Application No: M/5/22/PL
Site Address: 3 The Hard Elmer Middleton-On-Sea PO22 6JS
Description of works: Replacement residential dwelling. This application may affect a Public Right of Way.

Thank you for your internet representation made on 17th March 2022 which has been recorded as an objection with the comments as follows:

STREET SCENE - NORTH ELEVATION FROM THE HARD

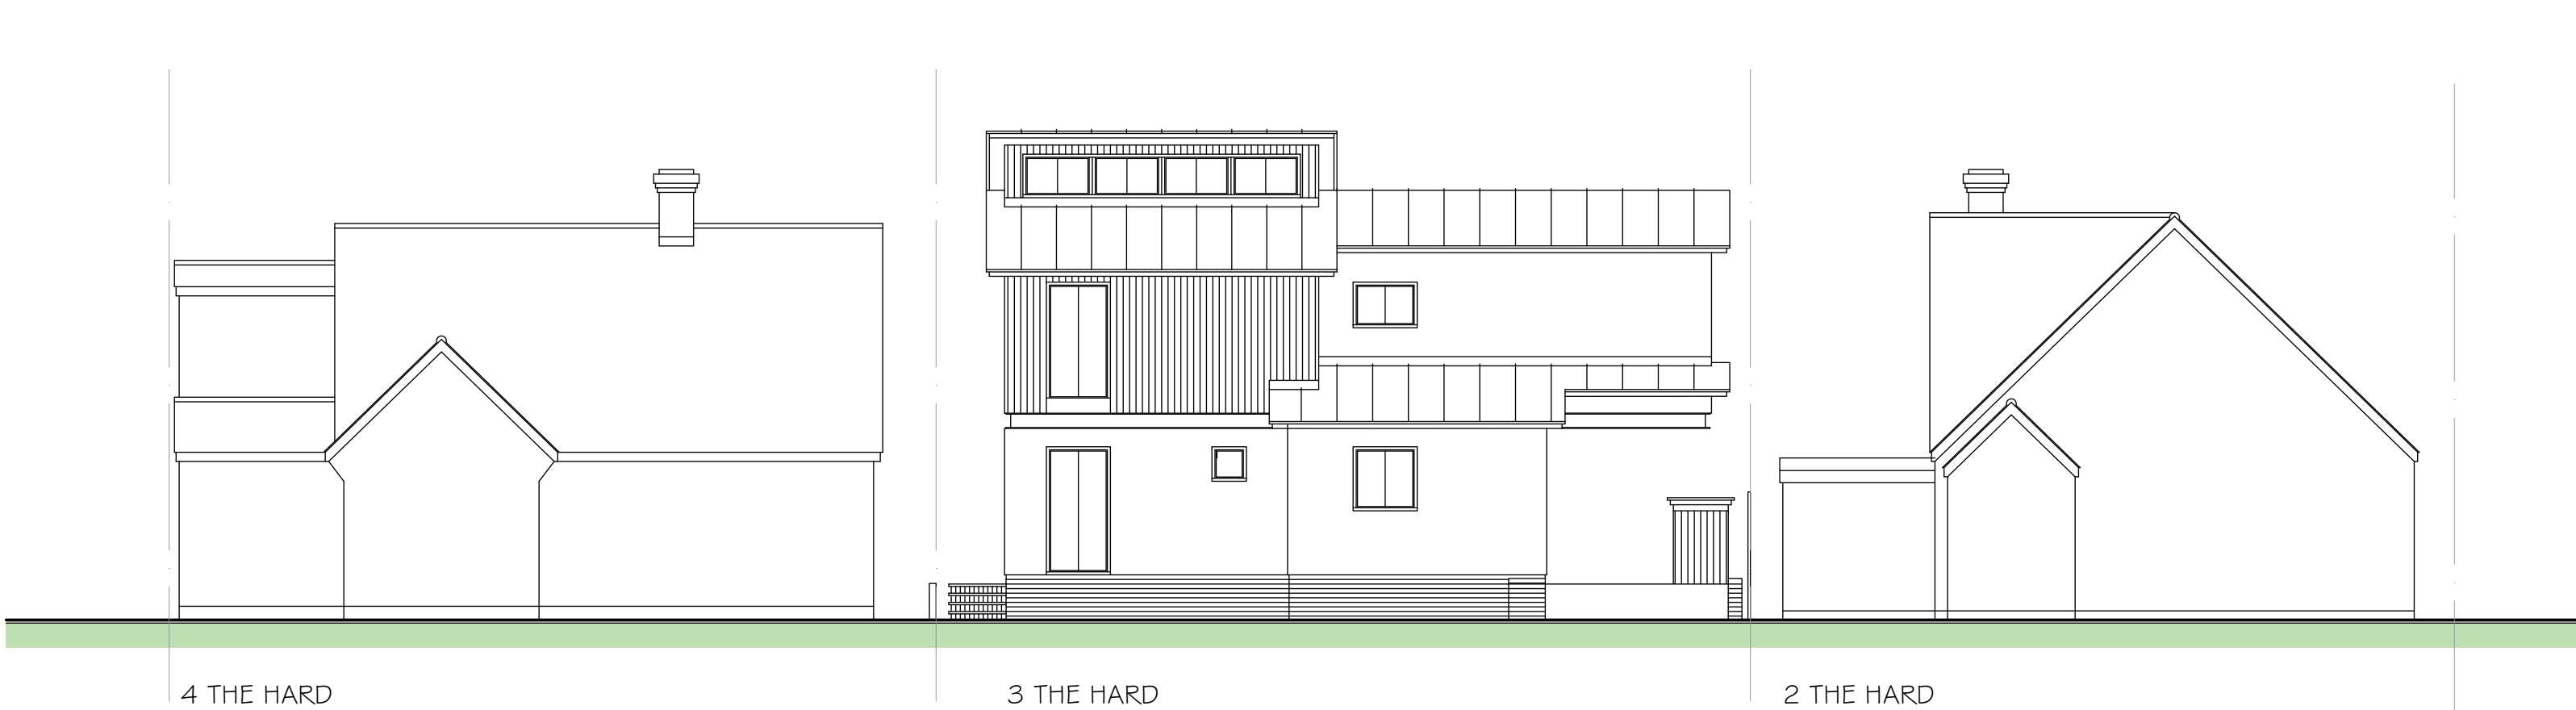
Out of character with the streetscene

DRAWING TITLE
PROPOSED ELEVATIONS, ROOF PLAN & SECTIONS

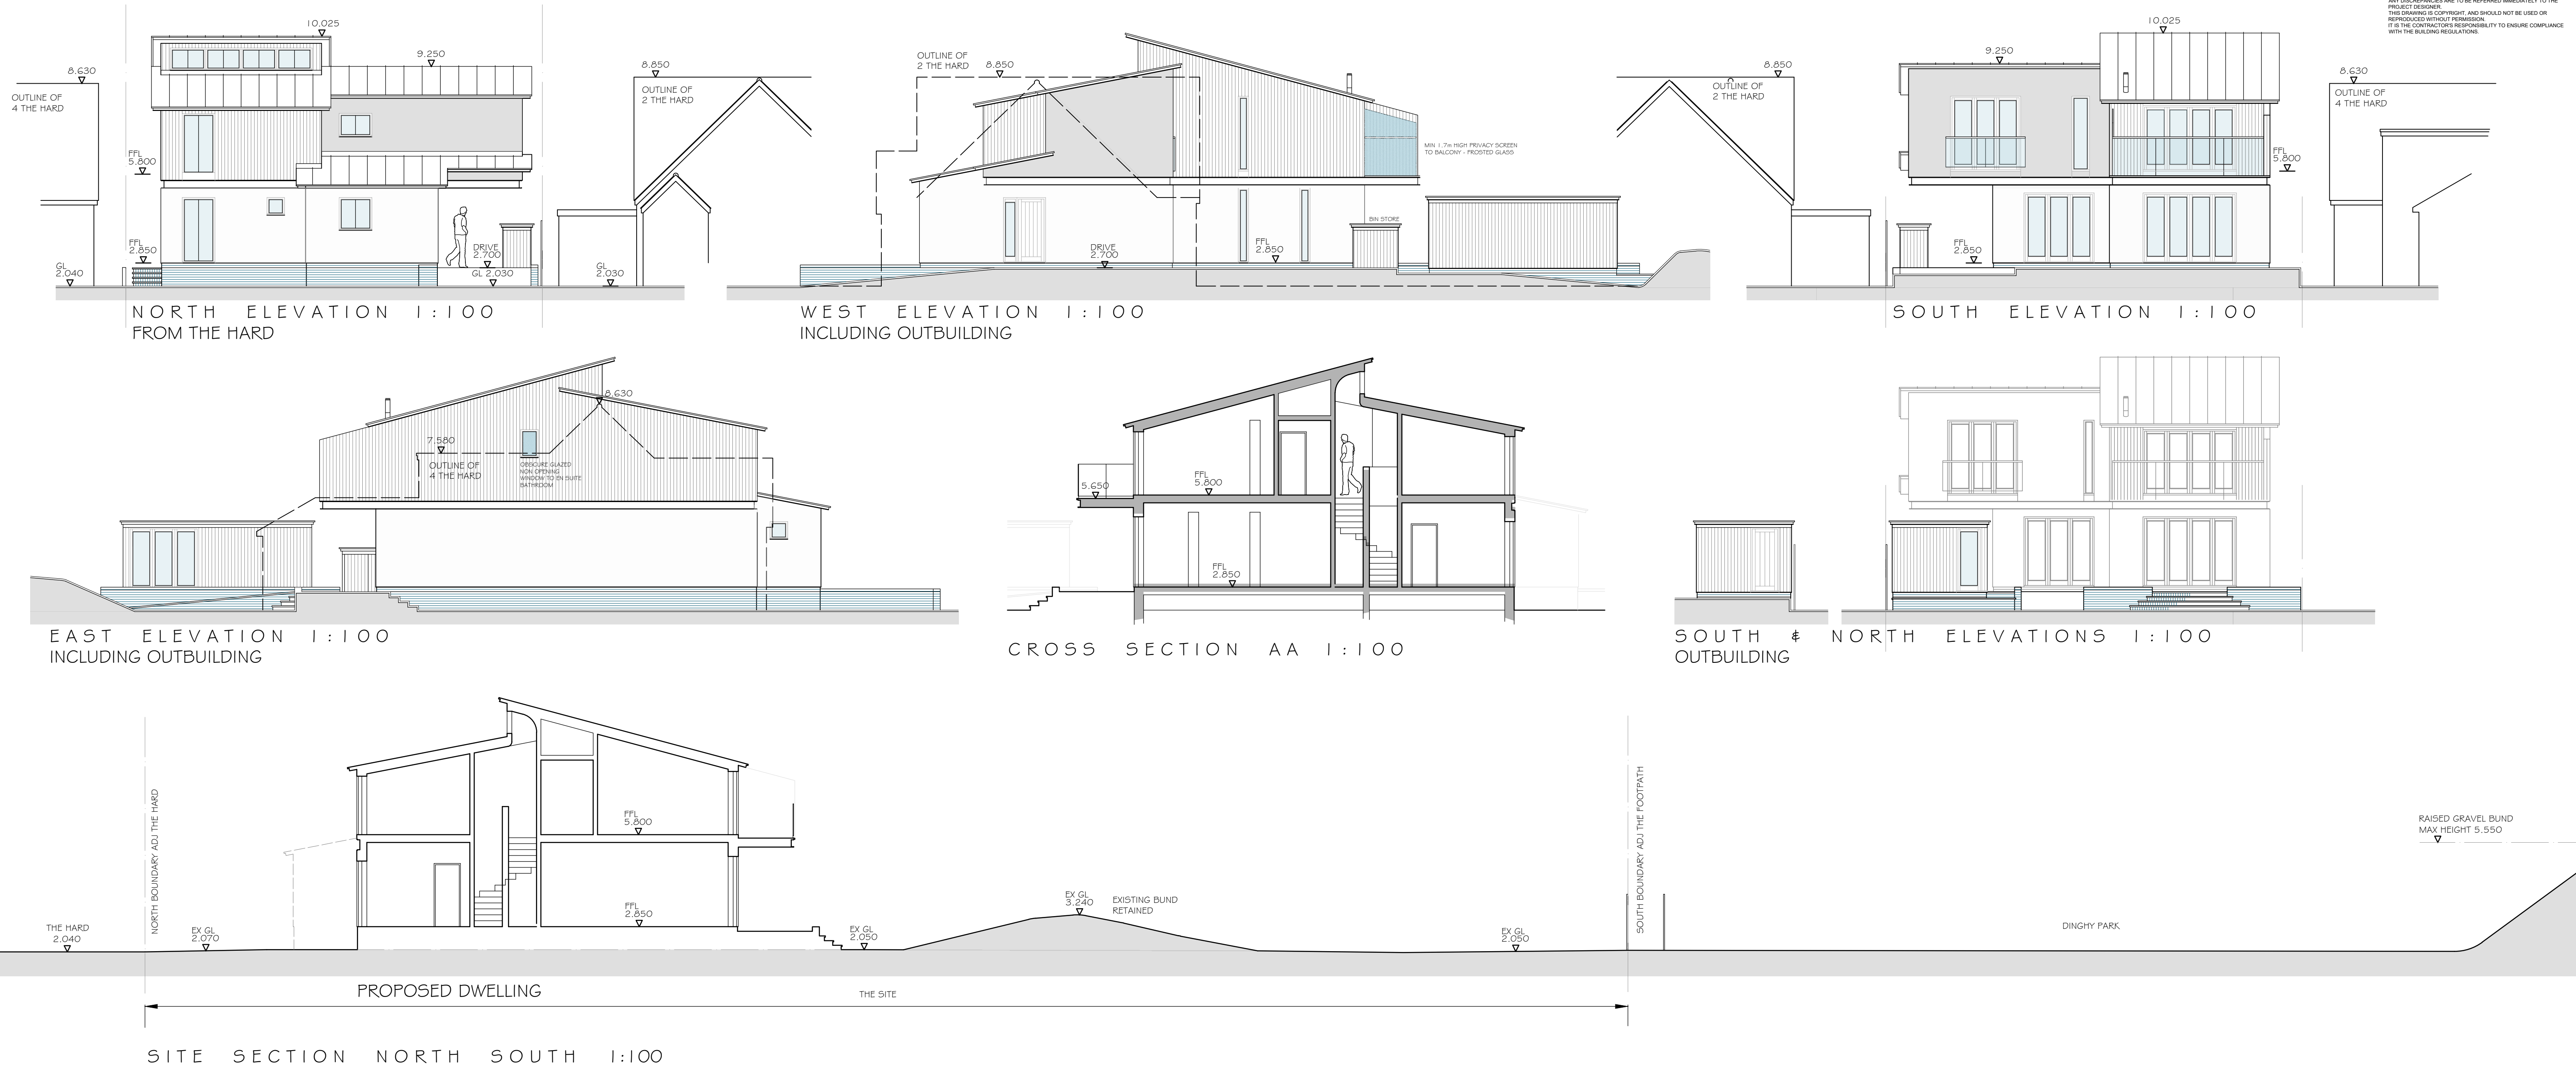
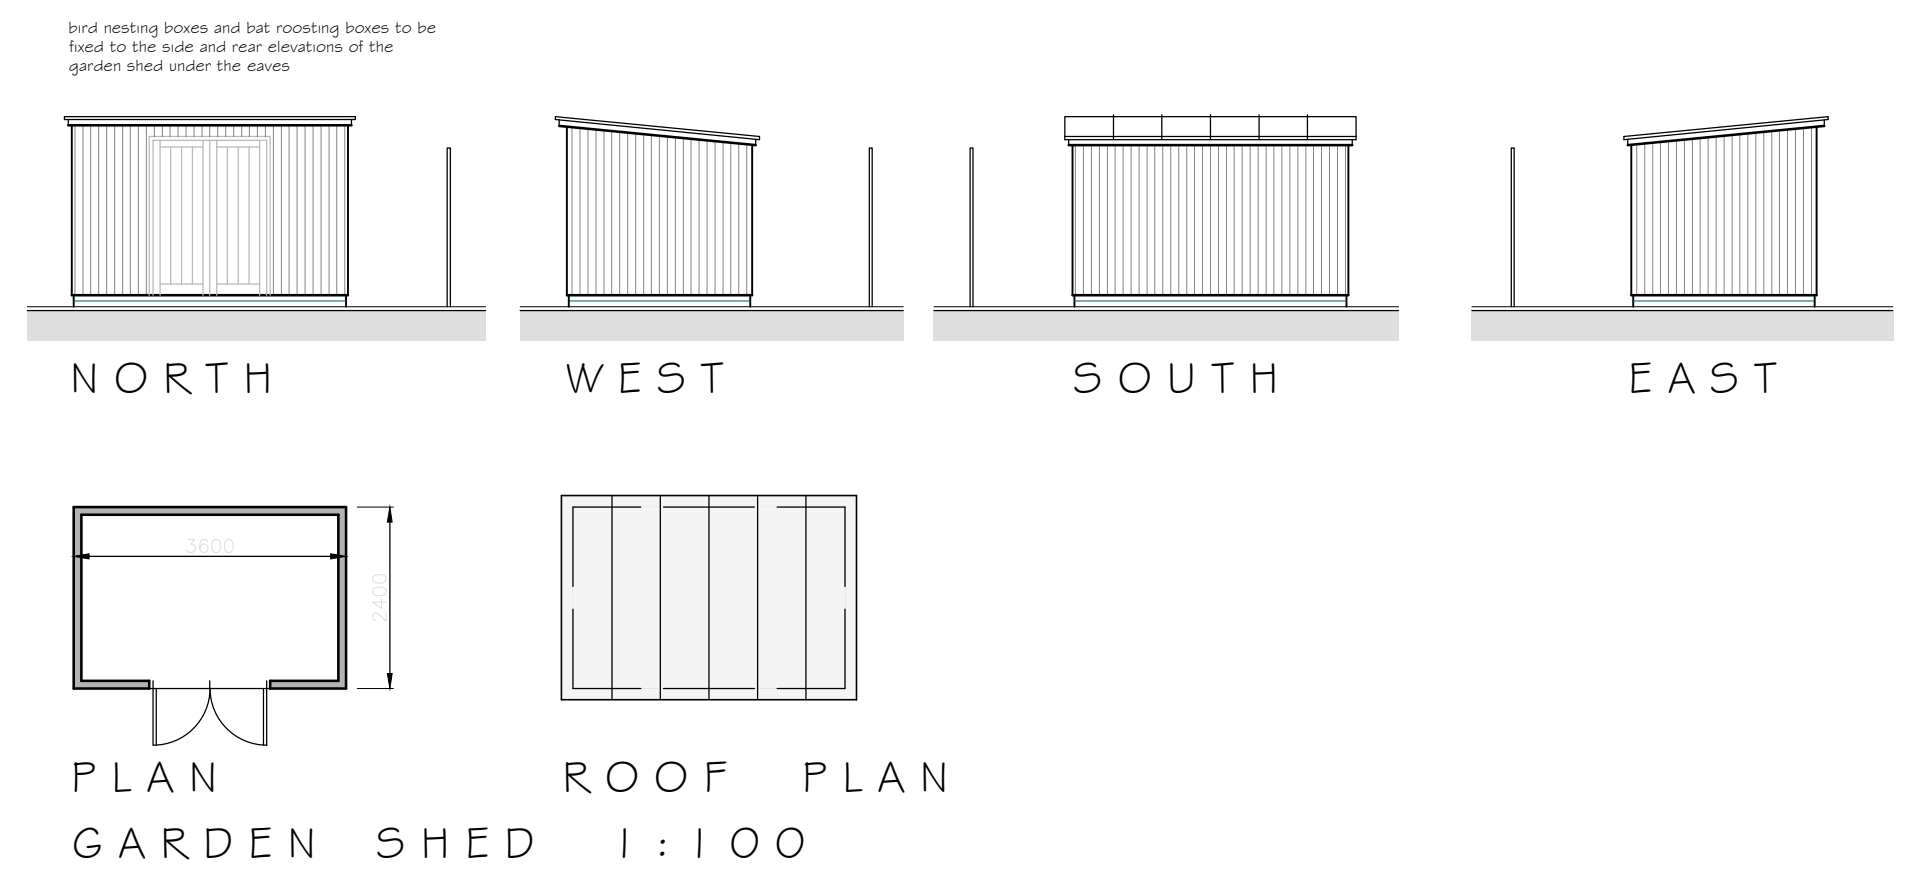
Overall height is out of keeping with surrounding properties
